From: Richard Castro-Parker
Sent: 24 June 2019 14:18
To: Planning.Responses
Subject: FW: Planning Application A/26/19/PL - Quiet Waters - Angmering

A/26/19/PL – removal of condition 20 of A/132/17/OUT, provision of EV charge points

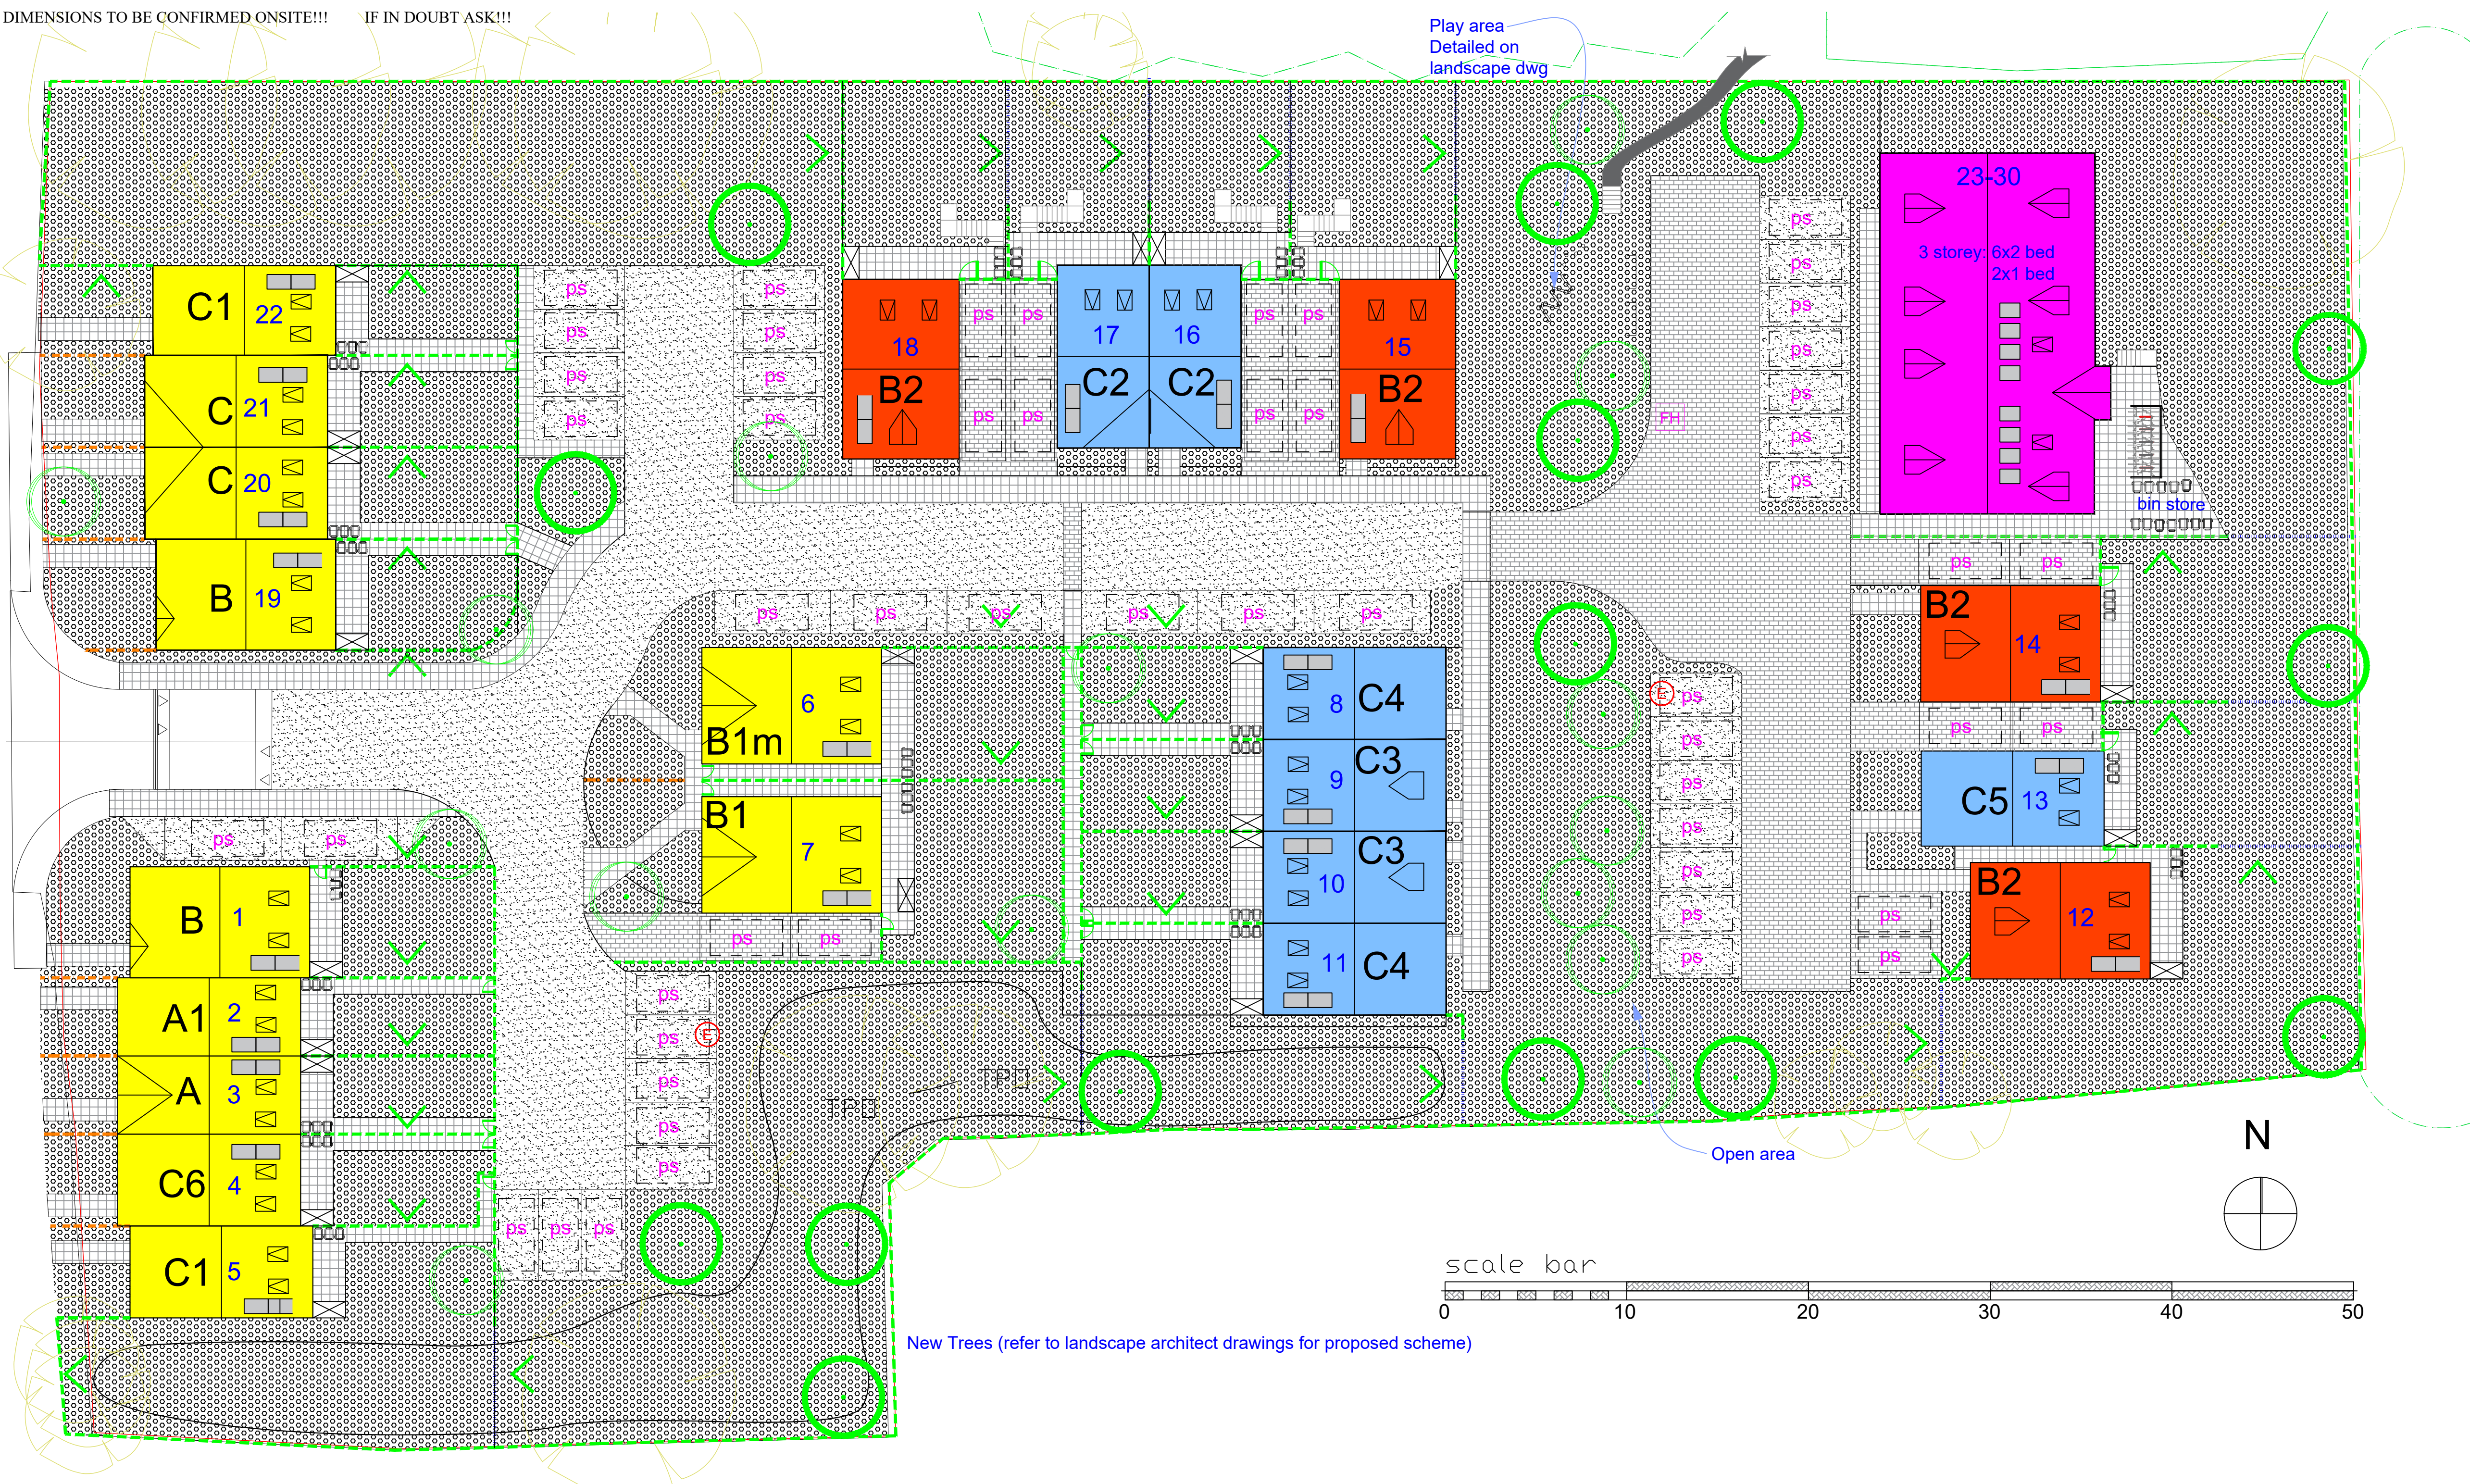
I note that the applicant has suggested that they provide only 2 EV charge points in communal or visitor car parking bays for the whole development of 30 dwellings. Environmental health have concerns about the proposals and do not consider that this is an adequate future provision for the site and does not provide a practical option for future residents of the site to charge electric vehicles.

Developments of this nature should be able to provide sufficient capacity to allow all future residents to charge electrical vehicles and the provision of just two points would not meet this.

As such environmental health would recommend that this application is refused.
